APPLICATION FOR: **65665/APP/2013/1349**

17 MAYLANDS DRIVE UXBRIDGE

Item No.	Report of the Head of Planning, Sport and Green Spaces		
Address	17 MAYLANDS DRIVE UXBRIDGE		
Development:	Single storey detached outbuilding to rear for use as a gym and store (Retrospective)		
LBH Ref Nos:	65665/APP/2013/1349		
Drawing Nos:	17003 17001		
Date Plans Received:	24/05/2013	Date(s) of Amendment(s):	24/05/2013
Date Application Valid:	29/05/2013

Title Existing / Proposed Plans & Elevations of Rear Out Building				Project: 17 Maylands Drive Uxbridge UB8 1BH	
Date Nov 12	Drawn By ASB	Rev No	Drg No	Scale 1/100 @ A1

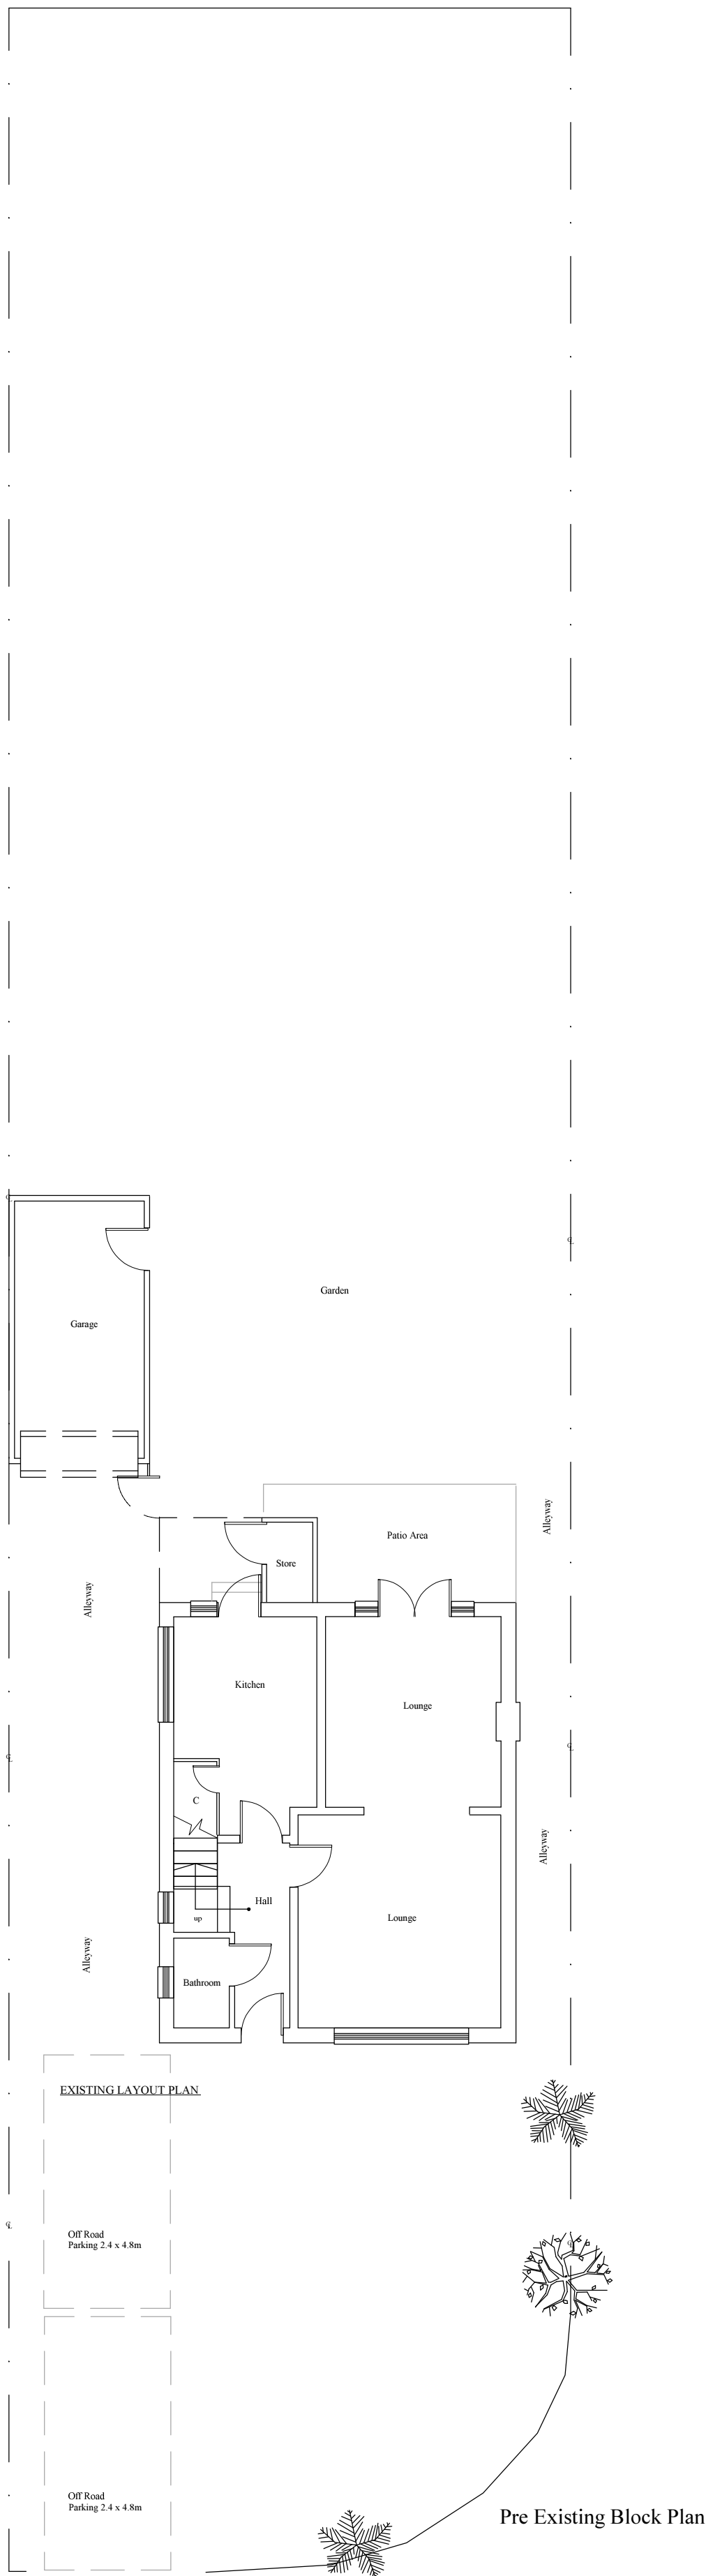
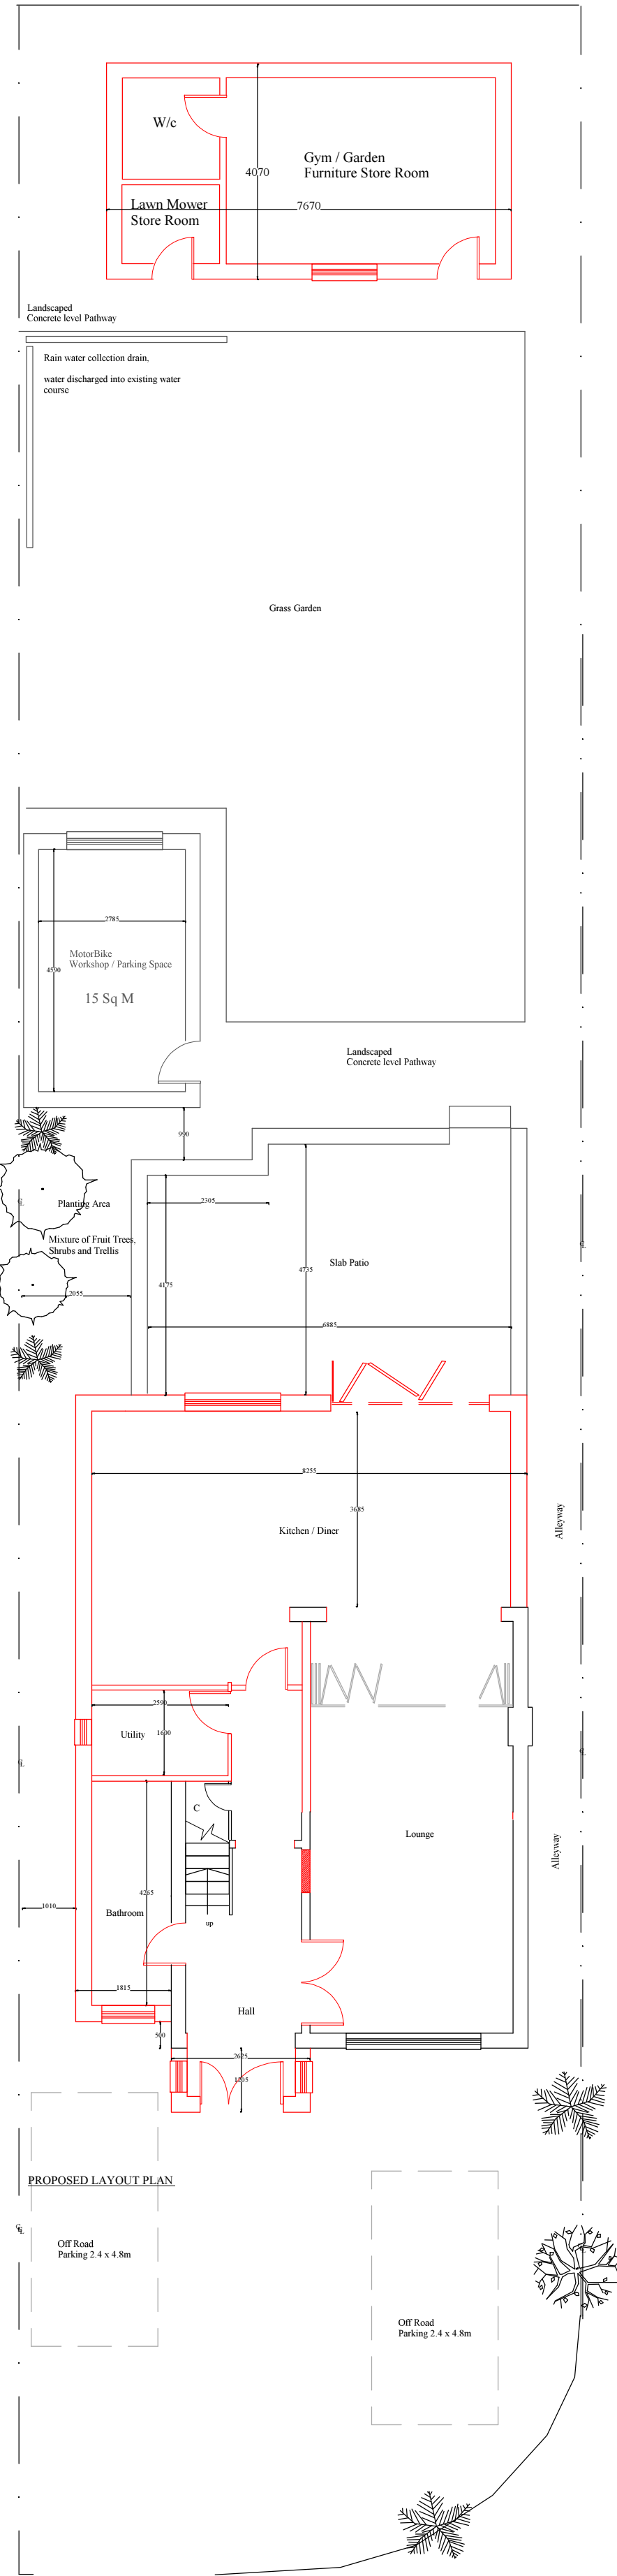
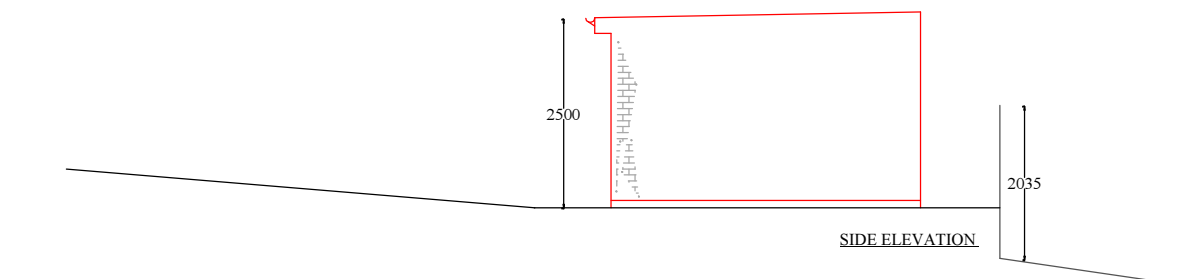
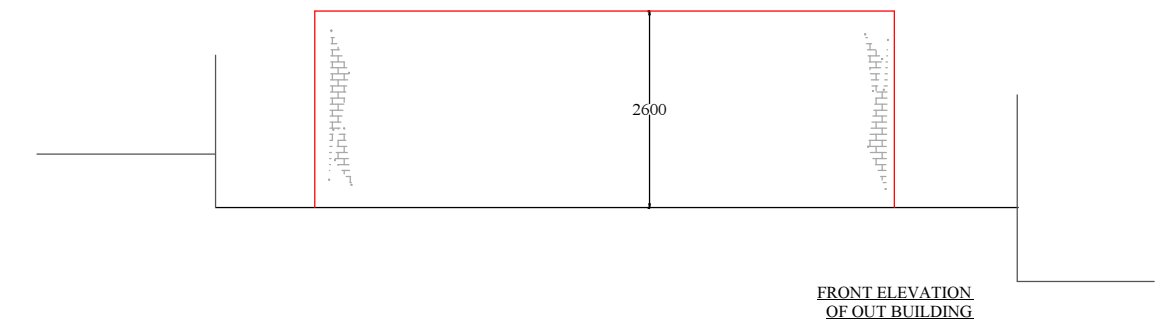
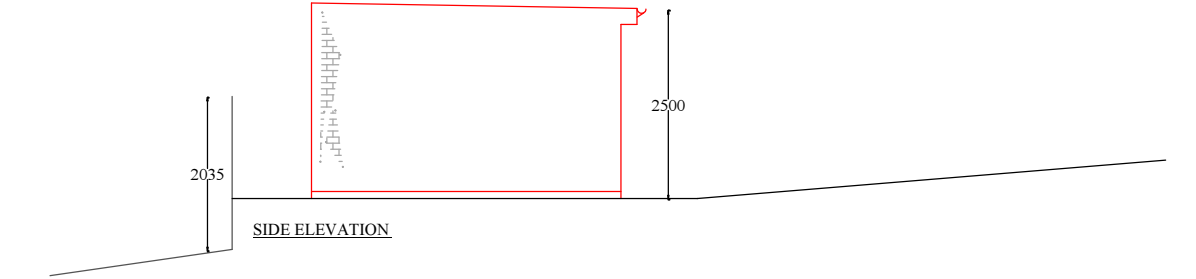
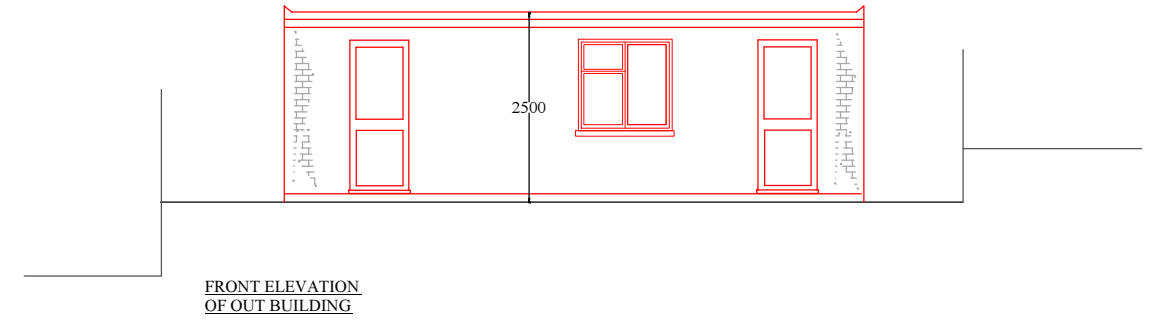
In most instances it is considered that a building with a footprint of greater than 30sq.m is of a scale which is not reasonably required for purposes ancillary to the residential use of the house. The outbuilding for which permission is sought is 31.5sq.m and is therefore considered to be of a scale which is not reasonably required for ancillary purposes. The fact that the outbuilding would have independent access separate from the main house and the design/fit out of the outbuilding; which includes separate rooms for a mower store and WC, and an internal fit out (in terms of materials) which is not considered to be normal for the uses stated on the plans are also considered to be indicative of a building which has not been designed or built for a use ancillary to the main residence. While the application form seeks only the retention of the outbuilding at the rear of the garden, the layout of other unauthorised structures on the site, including a second outbuilding which again has clearly not been designed for the purposes stated on the plans, also adds to concerns regarding the use of the structure.

However, in this instance the outbuilding has been carried out alongside 5 other aspects of unauthorised works at the property which are subject to enforcement notices requiring their removal. At the time of writing this report none of these other unauthorised structures has been removed, further all of these structures are clearly shown on the proposed site plan which the Local Planning Authority is being asked to approve as part of this application. As such, in this particular instance it is not considered that consideration of the outbuilding at the rear can be separated from the other works which have been carried out on site.

When considered cumulatively the proposed outbuilding in conjunction with other structures currently on the site has resulted in a significant increase in the built up appearance of this site and loss of amenity both for the occupiers of number 17 and number 19. Further, the resulting development fails to harmonise with the design features and architectural style predominant in the area and detracts from the appearance and quality of the Area of Special Local Character. As such the proposal is and is contrary to Policy BE1 of the Hillingdon Local Plan Part 1 adopted in November 2012 and Policies BE5, BE20, BE21 and BE24 of the Hillingdon Local Plan Part 2 adopted in November 2012.

The proposal is for a detached structure which it is considered is capable of independent occupation from the main dwelling and is thus tantamount to a separate dwelling in a position where such a dwelling would not be accepted due to increased noise and

disturbance impacting on the amenity of neighbouring occupiers, a lack of amenity space for future occupiers, overlooking between the main dwelling and the outbuilding, it is therefore contrary to policy BE1 of the Hillingdon Local Plan Part 1 adopted in November 2012 and policies OE1, BE19, BE23 and BE24 of the Hillingdon Local Plan: Part Two - Unitary Development Plan Saved Policies (November 2012) and the Hillingdon Design and Accessibility Statement - Residential Extensions.

The outbuilding which is the subject of this application, when considered in conjunction with other works carried out on the site (and clearly shown on the proposed plans) results in a significant increase in the built up appearance of this site and loss of amenity to the occupiers of number 17 and number 19. The development is therefore contrary to policy BE1 of the Hillingdon Local Plan Part 1 adopted in November 2012 and policies BE20, BE21 and BE24 of the Hillingdon Local Plan: Part Two - Unitary Development Plan Saved Policies (November 2012).

The outbuilding which is the subject of this application, when considered in conjunction with other works carried out on the site (and clearly shown on the proposed plans) is considered to result in a development which fails to harmonise with the design features and architectural style predominant in the area. The development therefore detracts from the appearance and quality of the North Uxbridge Area of Special Local Character and is contrary to Policy BE5 of the Hillingdon Local Plan: Part Two - Unitary Development Plan Saved Policies (November 2012).
